DRB Application No.: 02-01569 (SPS)
Project Name: **EAGLE SPRINGS SUBDIVISION**
Agent: Mark Goodwin & Associates

Project # **1002183**
EPC Application No.:
Phone No.: 828-2200

DEVELOPMENT REVIEW BOARD--SPEED MEMO

Development Review Board Comments

All open space requirements are met on the lot with the dwelling per provisions of Section 14-16-3-8 (A)(1).

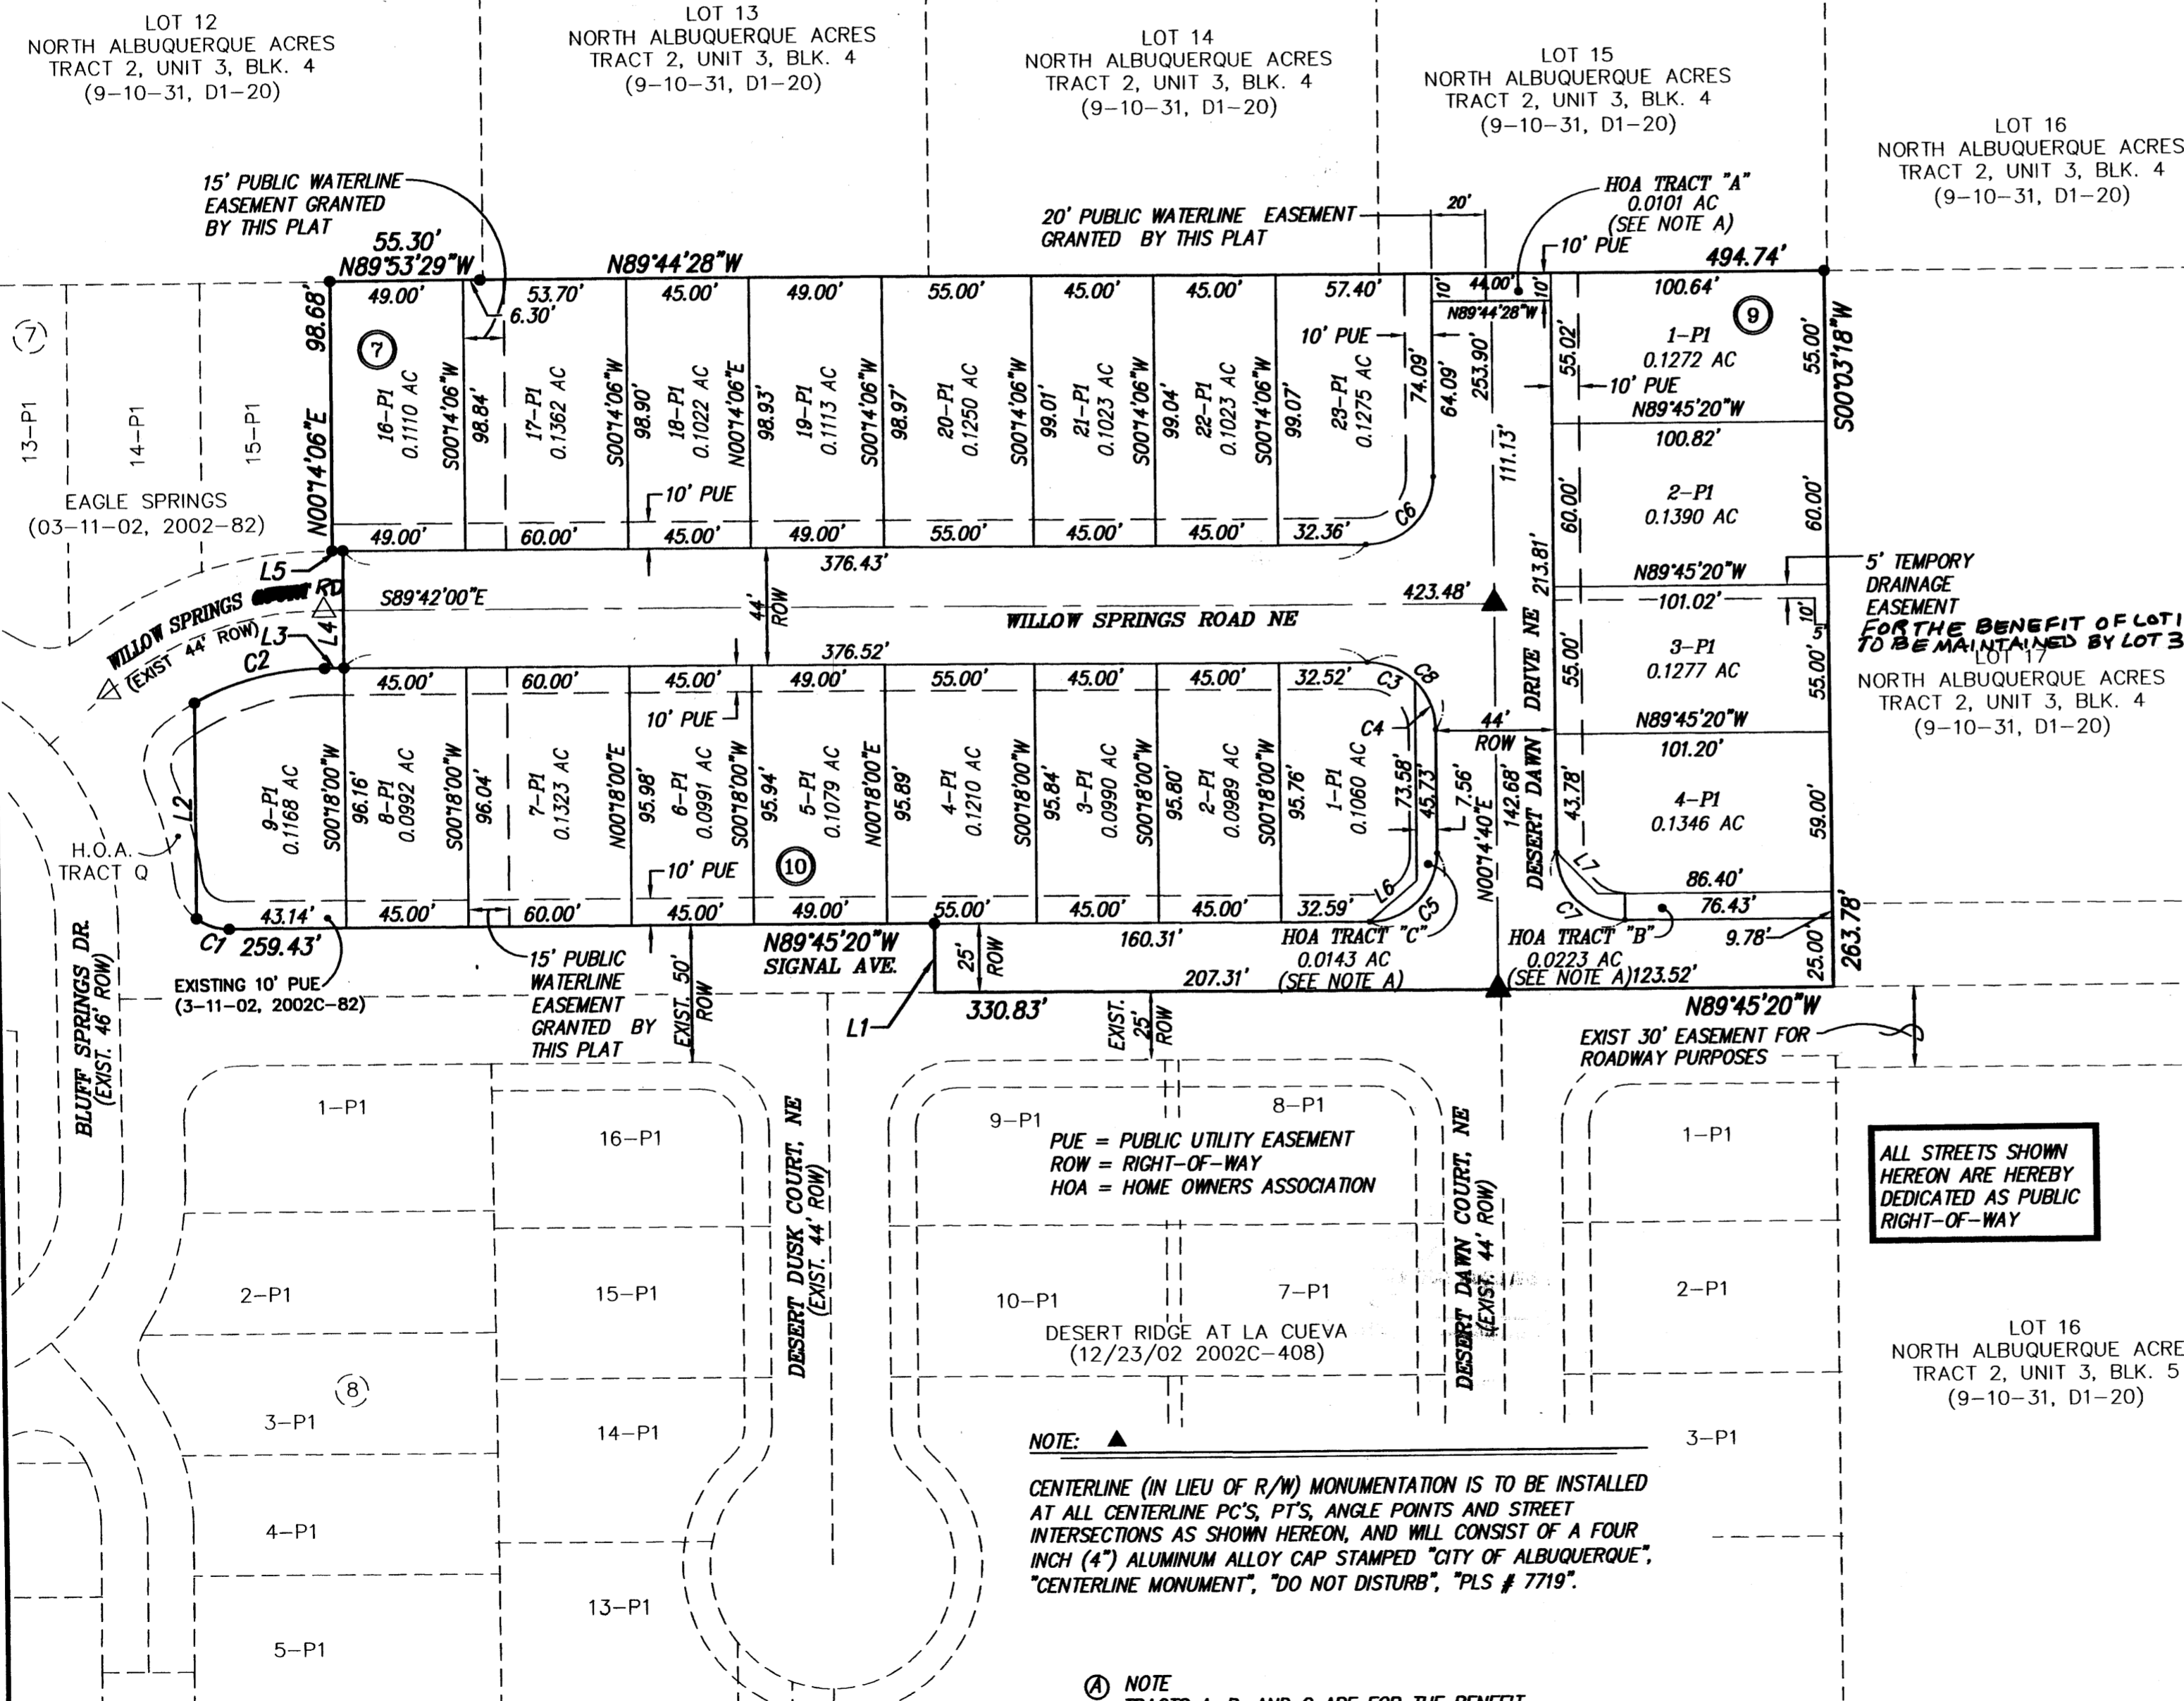
The following open space note needs to be added to the plat:

All open space requirements are met on the lot with the dwelling per the provisions of Section 14-16-3-8 (A) (1).
